From: Simon Davis
Sent: 11 June 2019 12:23
To: 'Lauren Wiltshire' [REDACTED]
Subject: RE: Planning Consultation on FP/42/19/DOC

Comment from Greenspace

I would **not recommend discharge of Condition 12** on this application FP/42/19/DOC imposed under FP/171/18/PL until this information is submitted for approval.

Project: Wellers Close Hampshire Homes Group	
Drawing: Soft Landscaping Concept	
Date: May 2018	Drawn by: JA
Scale: 1:200 @ A1	Revision: -

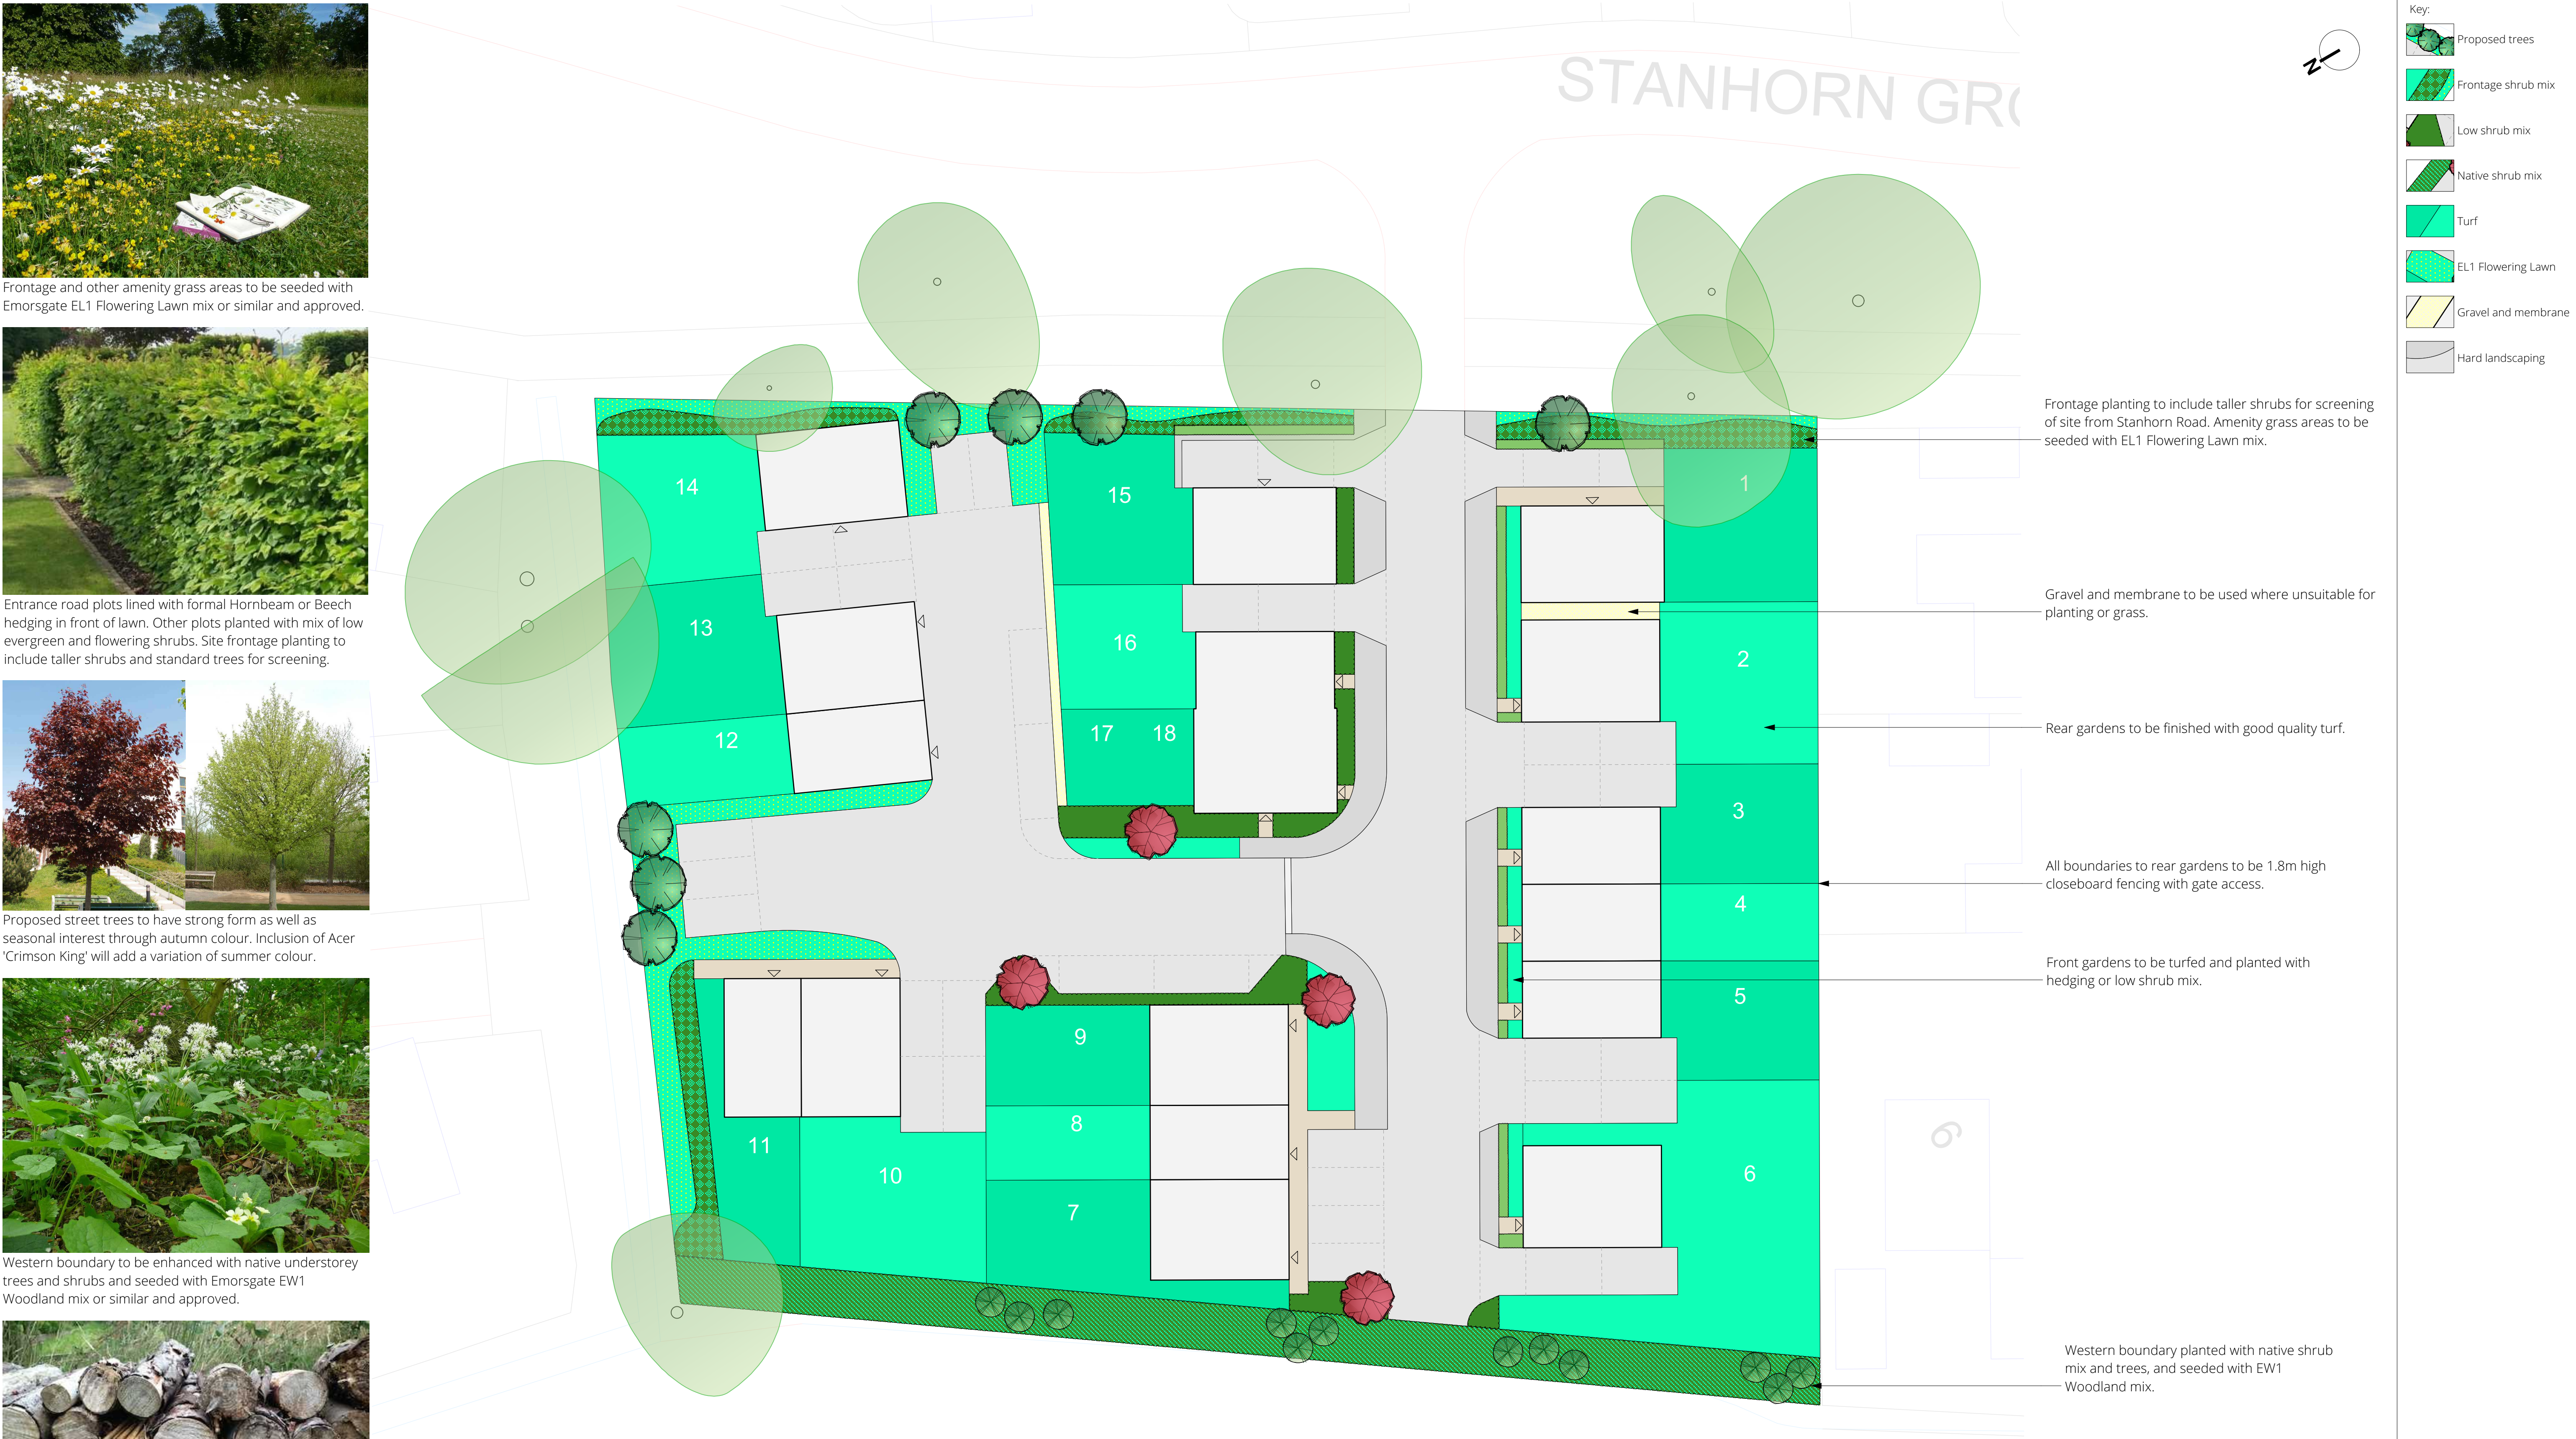
The information supplied in Yes Landscape Consultants Soft Landscape Concept Dwg May 2018 is an indicative concept drawing and does not satisfy the detail required under Condition 12 which asks for a scheme of landscaping hard and soft to be submitted along with existing vegetation and protection measures to be employed. The information needs to be a detailed scheme in plan form with a suitable planting mix allowing for any mitigation and screening as may be required. The detail needs to include species type, actual numbers, planting densities and size at time of planting.

I have had confirmation from my landscaper that we will have full details Thursday for review. Will this be acceptable?
